City of Portland, Maine - Building or Use Permit Application

Permit No: 07-1383	Issue Date:	CBL: 123 L005001
------------------------------	--------------------	----------------------------

Location of Construction: 251 WOODFORD ST	Owner Name: JAGGER ALLAN D	Owner Address: 40 O'BRION ST	Phone:
Business Name:	Contractor Name:	Contractor Address:	Phone:
Lessee/Buyer's Name	Phone:	Permit Type: Change of Use - Dwellings	Zone: B-1/R5

Project Name: After the Fact Review
Address: 251 Woodford Street
Applicant: Allan Jagger
Planner: Barbara Barhydt

WOODFORD STREET  
PAVED PUBLIC HIGHWAY  
RIGHT-OF-WAY

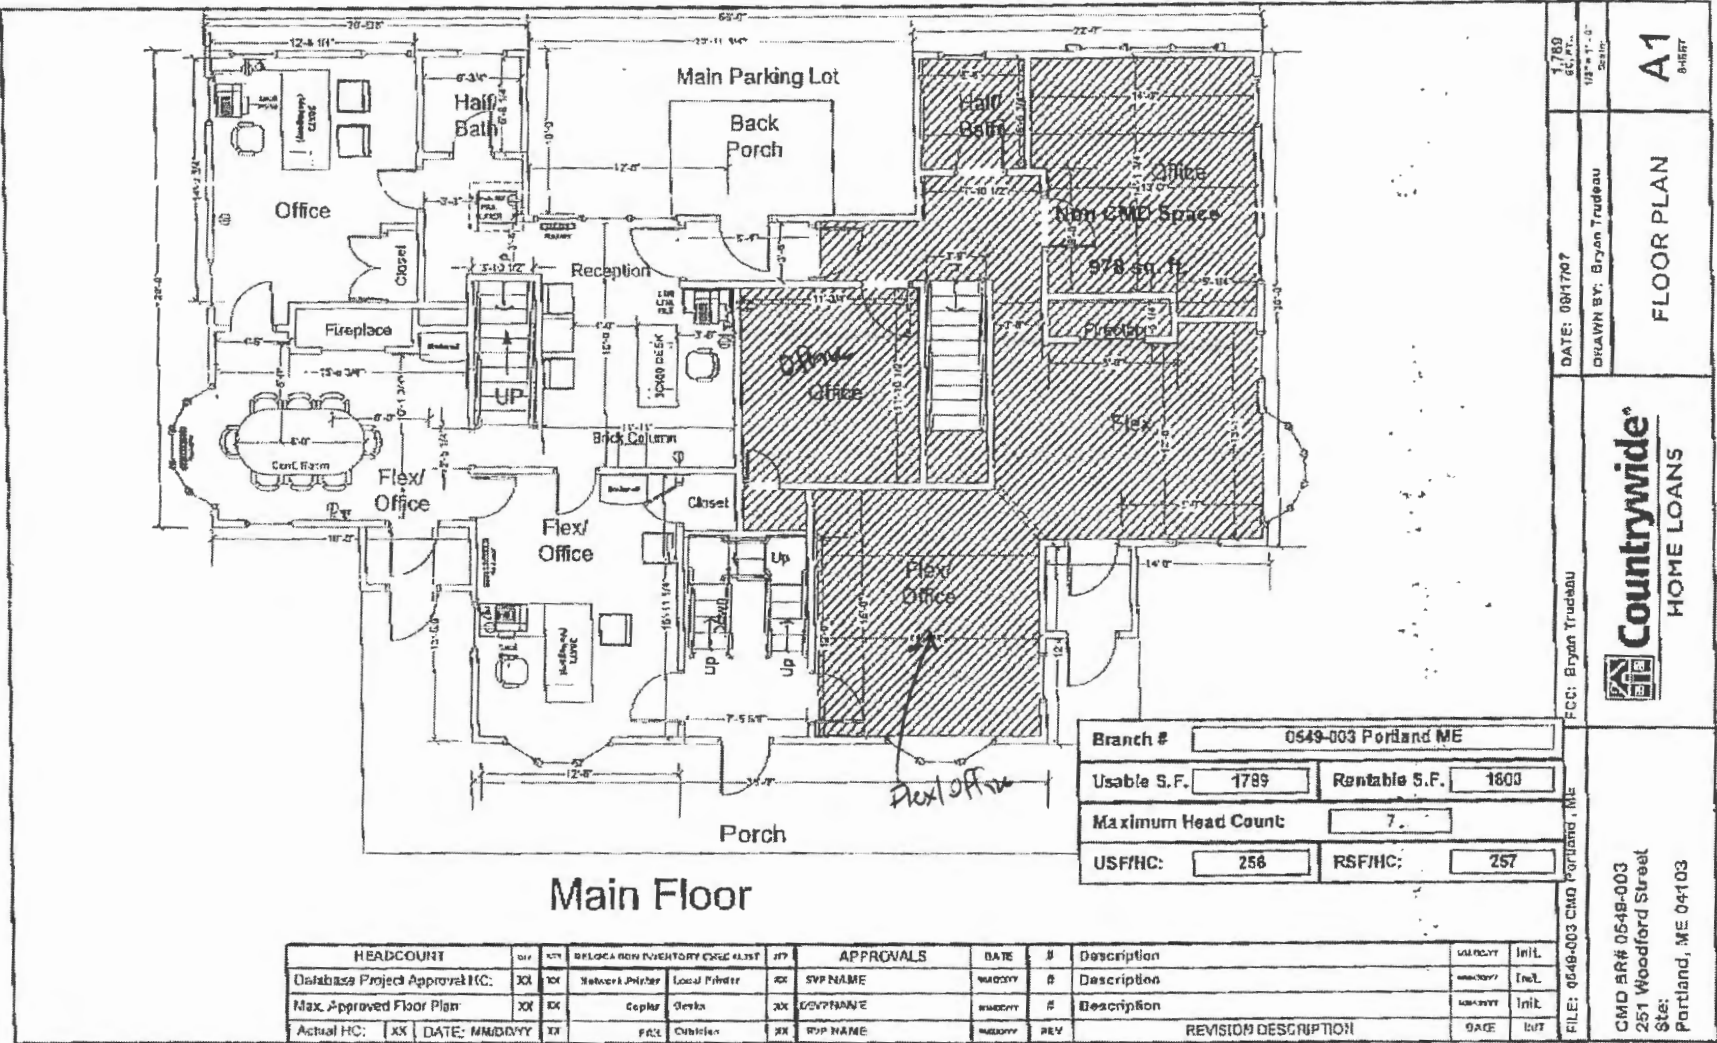
I reviewed the revised plans received on 1/20/10. It is showing that 18' of pavement will be removed. This is approvable under zoning. Section 14-51 allows a 30' extension of the B-1 Zone into the R-5 Zone. My one condition is that the proposed dumpster enclosure be put in the area of the B-1 Zone, not the R-5 Zone. It is noted that the previous submittal did not show a dumpster enclosure anywhere on the lot.

3. The property at 251 Woodfords Street is divided between the B-1 zone for the front portion of the property running parallel to Woodford Street and the R-5 zone for the rear portion of the property as shown on the site plan dated 12/12/07. Marge Schmuckal, Zoning Administrator, has reviewed the after-the-fact site plan for a parking lot at 251 Woodford Street, which is to serve the change of use of the existing building to an office use and one dwelling unit. She has determined that the paved area may extend 30 feet beyond the B-1 zone line into the R-5 District. The paved parking area extends approximately 50 feet beyond the B-1 and R-5 zone line, thus the parking area is located 20 feet into the R-5 Zone.

Ms. Schmuckal has ultimately concluded that you must either show that the extra pavement is removed or some other approvable method for restricting parking is placed in the area.

1. A revised site plan must be submitted that shows the removal of twenty feet of pavement within the R-5 zone and the stabilization of the site with loam and seed.

2. The driveway leading to the existing garage may remain.
3. A minimum of six parking spaces must be shown on the plan.
4. The revised site plan must be reviewed and approved by the Planning Authority.

5. Erosion and sedimentation controls meeting DEP's best management practices will be required during construction.
6. Adequately screen the dumpster with solid fencing.

1. A revised plan has been prepared. I measured the distance from the edge of pavement in the parking area to the zone line and determined 18 feet +/- of pavement must be removed. I recalculated the change in the impervious ratio of the site and noted it on the plan.
2. I have left the driveway to garage on the plan.
3. There are still 13 parking spaces on site which includes the garage.
5. A detail sheet has been prepared outlining the DEP procedures for Erosion and Sedimentation control.
6. A dumpster enclosure has been placed on the plan and shown on the detail sheet.

1,789 sq. ft.  
 1/8" = 1'-0"  
 3/16" = 1'-0"  
**A2**  
 SHEET

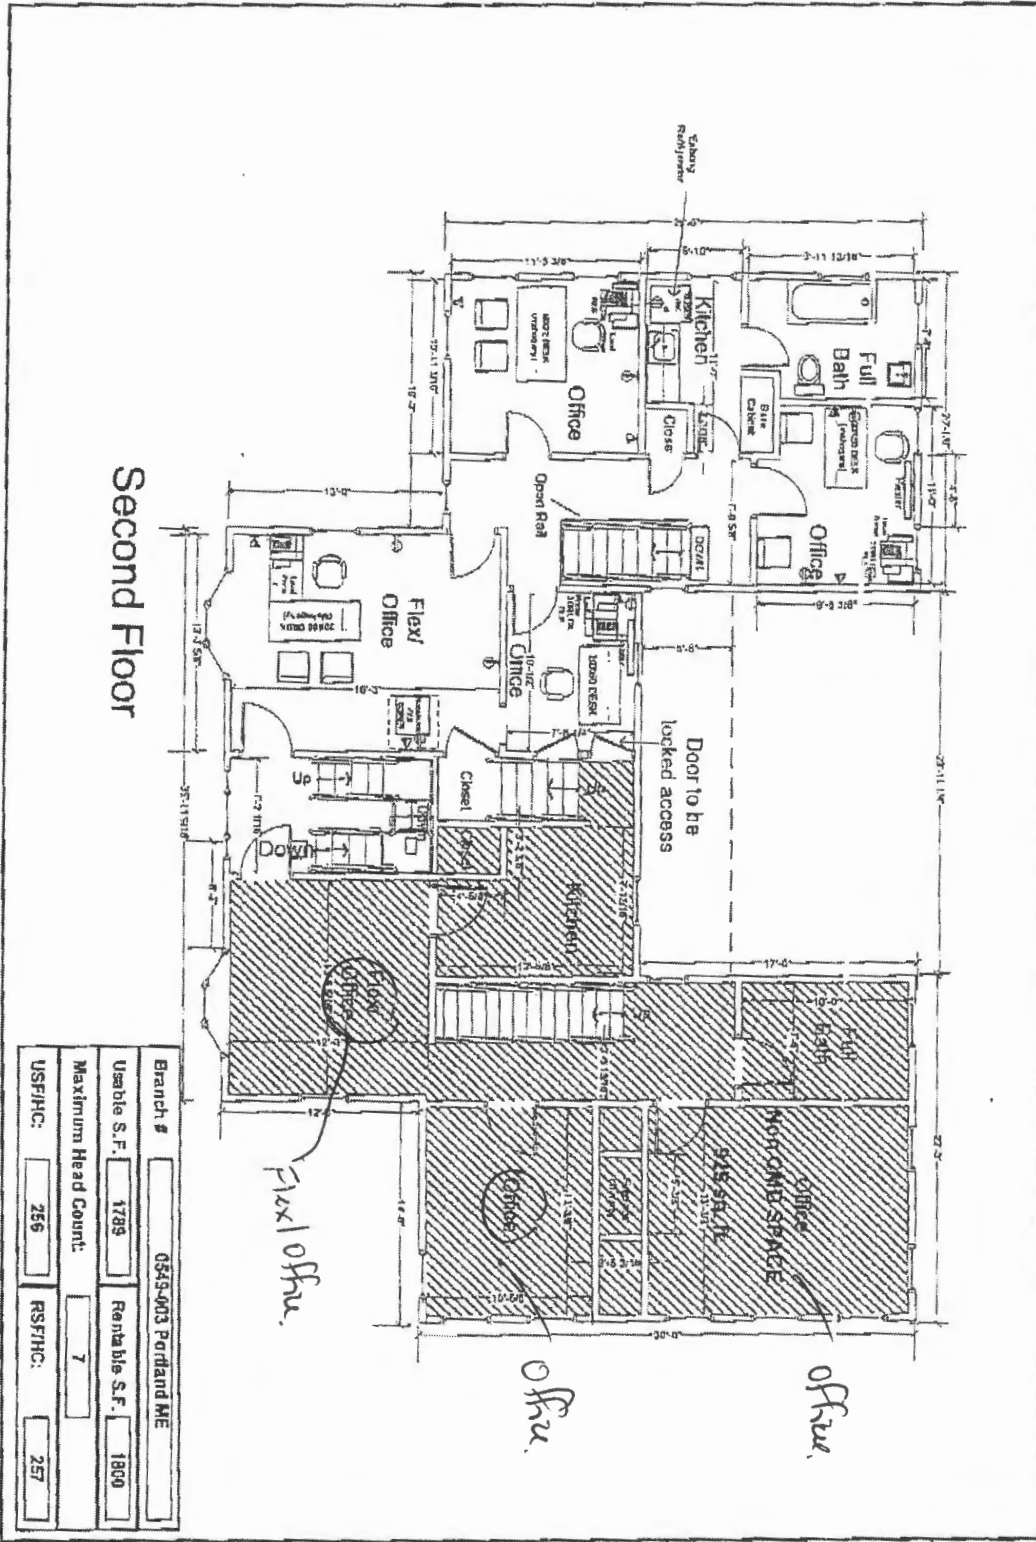
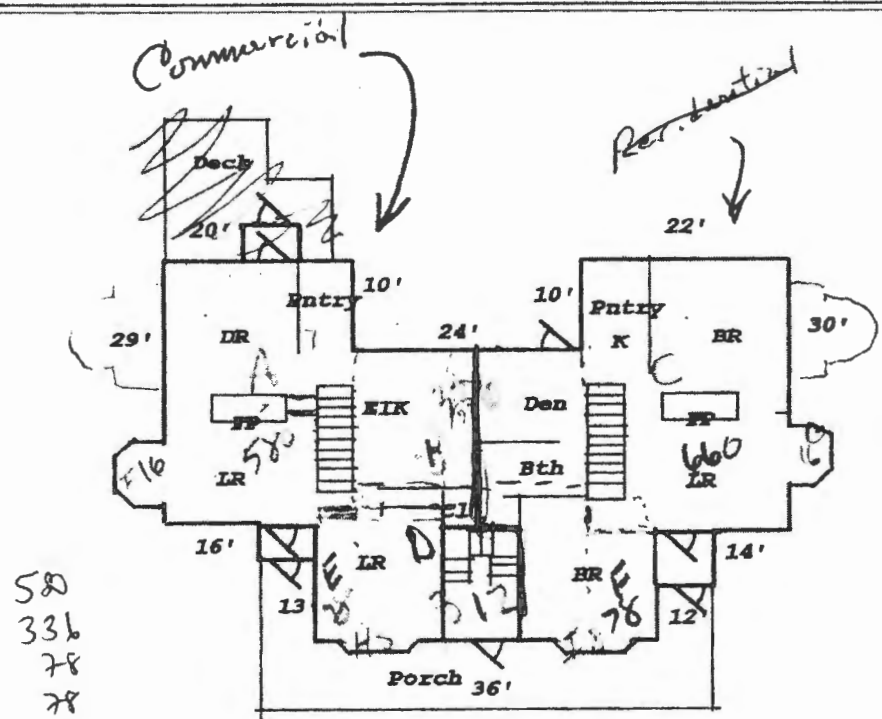
Note: Floor area for office is 1936 sf, so needs to show 5 parking spaces and one for existing dwelling unit for a total of 6 parking spaces. **Ok to Issue:**
